A1 Birtley to Coal House

Scheme Number: TR010031

Statement of Common Ground with Gateshead Council

Version	Date	Status of Version
Rev 1	20 April 2020	Draft

Drawing Title COMPOSITE LAND AND WORKS PLANS
SHEET 2 OF 5
REGULATION 5(2)(i)

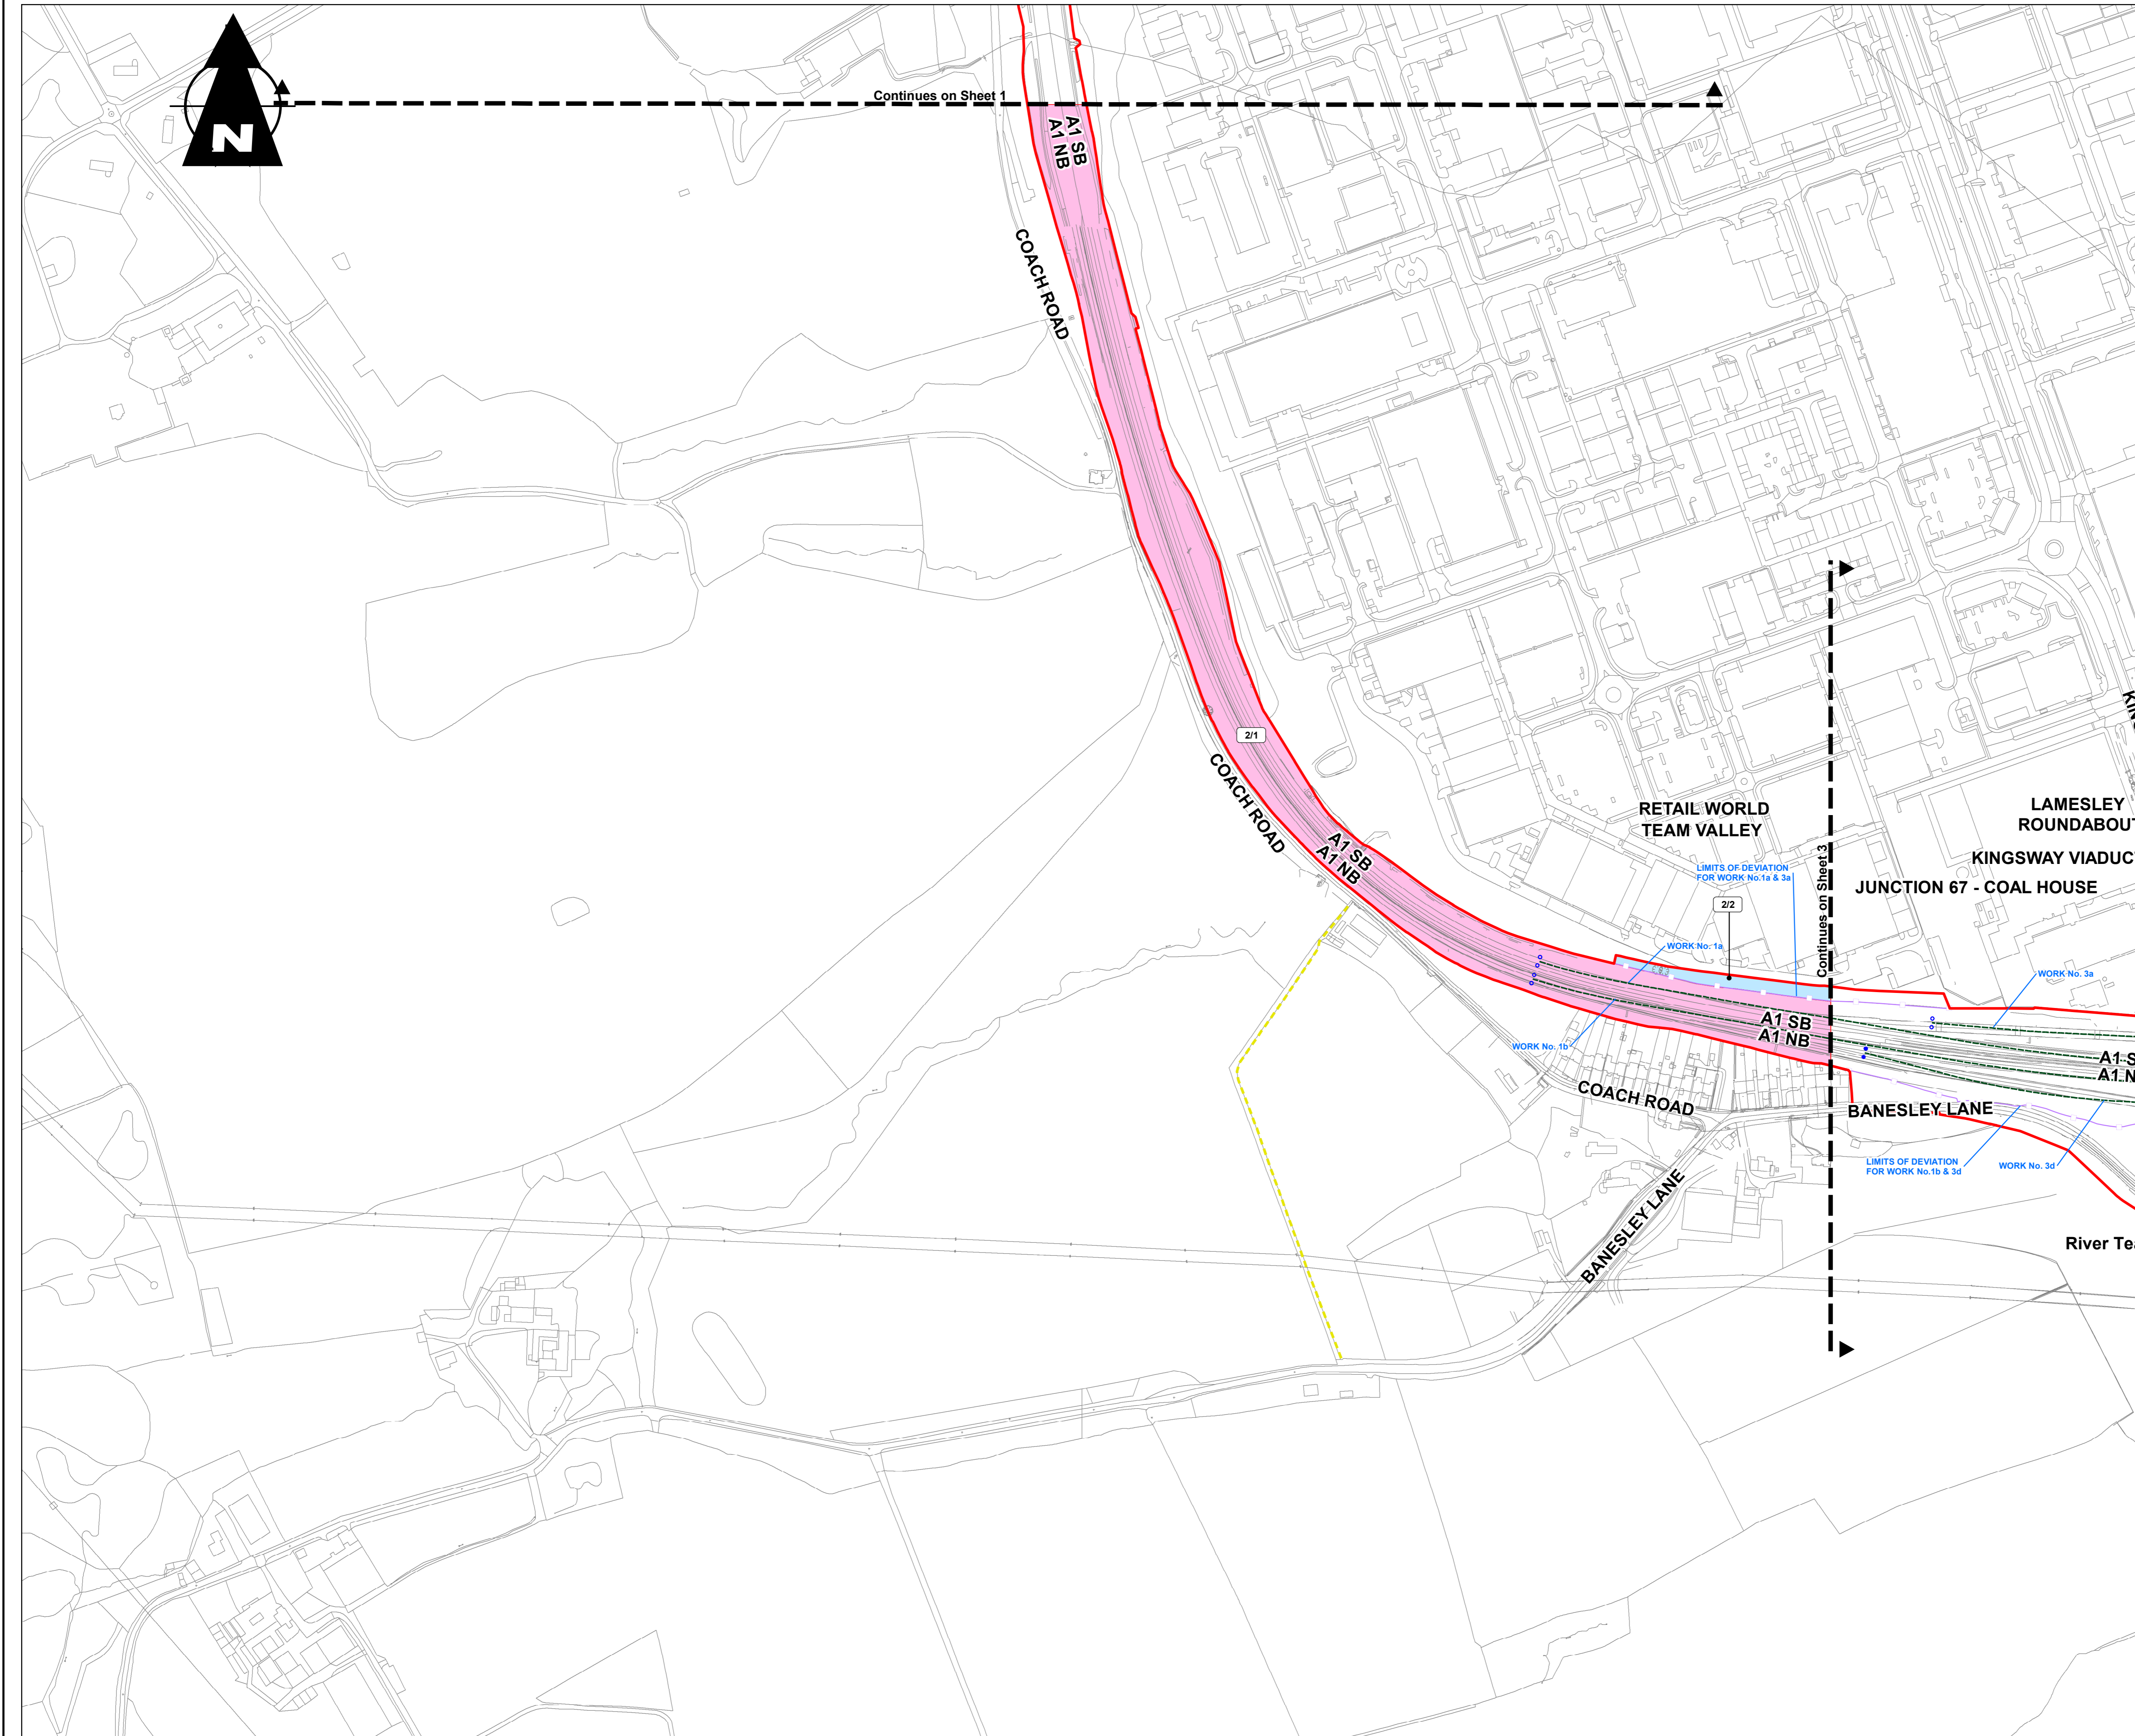
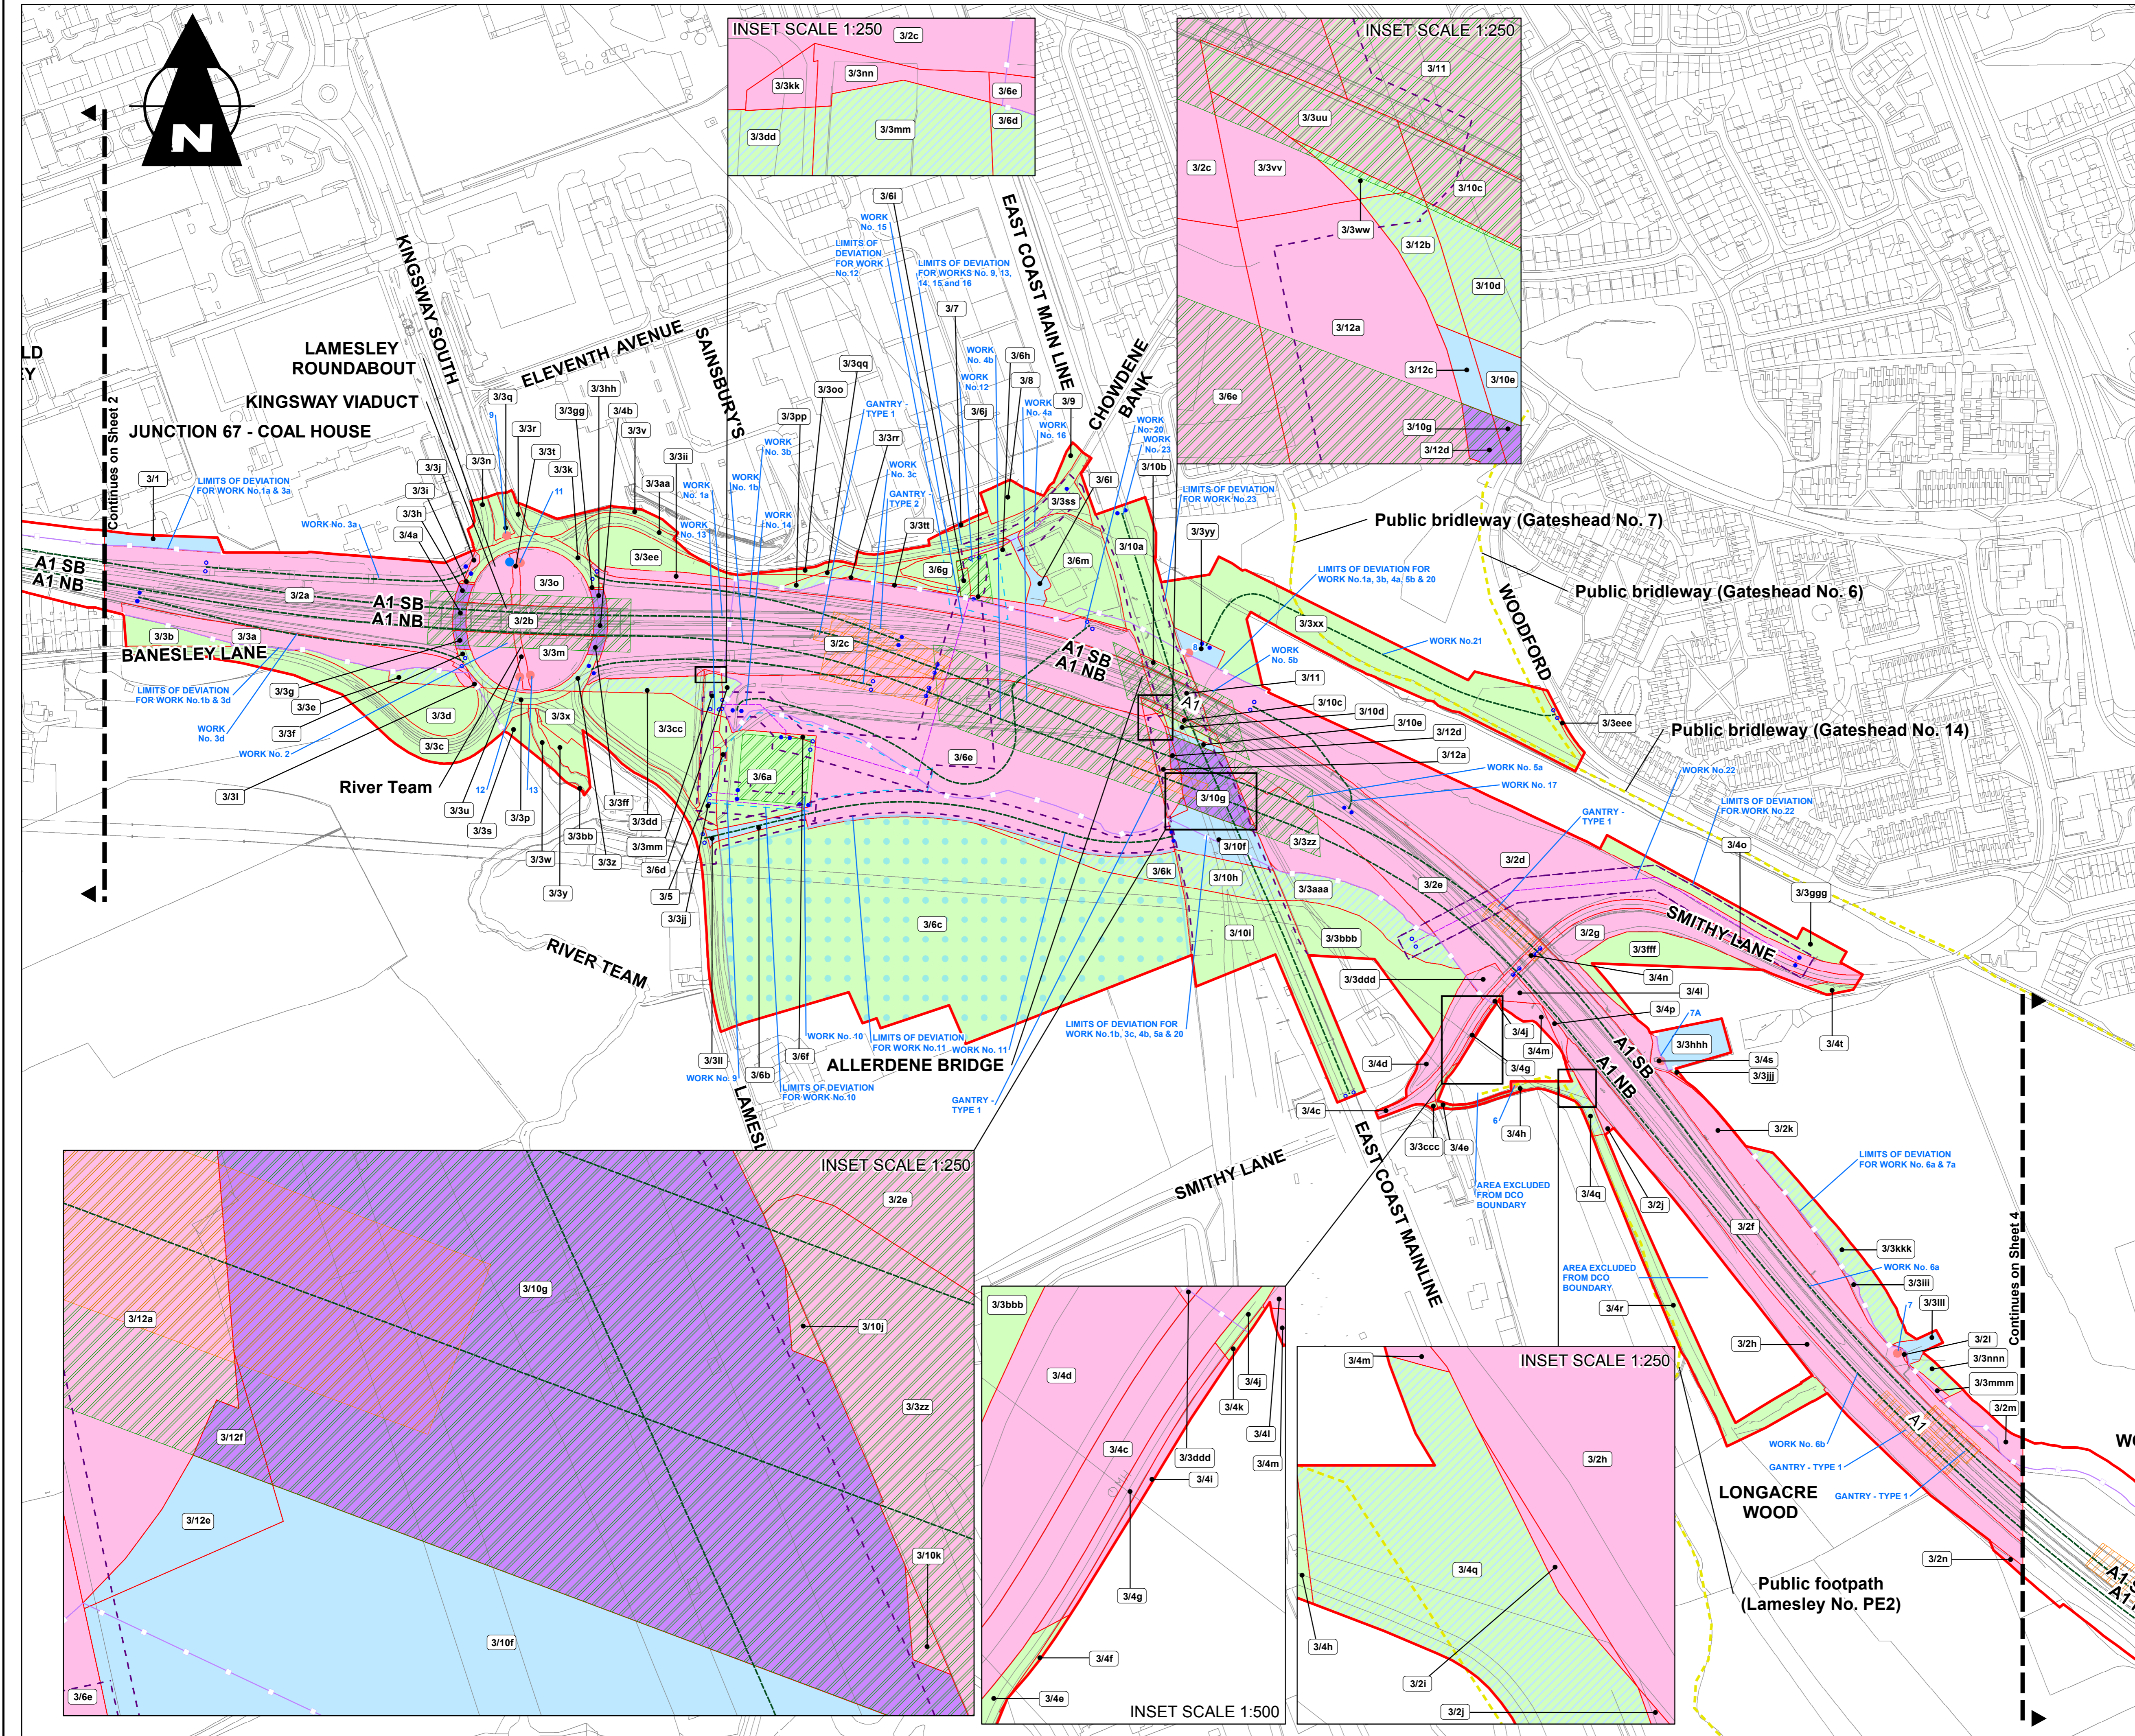
Section	Sub-section	Gateshead Council Position	Highways England Position	Status
			Details are currently under discussion with Gateshead Council.	
Works Plans [APP-007]	Sheets 3, 4, 5, 6 & 7	Under discussion post DCO decision. Workshop to be arranged prior to Deadline 3	Gantries will be provided along the Scheme, although at this stage, their locations along the Scheme are not fixed to allow flexibility in later design stages. Further details of current proposals have been included in Appendix 2.0B Gantry Report [EXA/D4/015] of the Applicant's responses to the ExA's Second Written Questions submitted at Deadline 4. A telephone conversation was held with Clare Richardson from Gateshead Council on 24 March 2020. A further call between WSP and Gateshead Council was held on the 10 April 2020 to get feedback from Ecology, heritage and Landscape officers. This has informed further development of the design of the interface between the Angel of the North and the Scheme.	Under Discussion
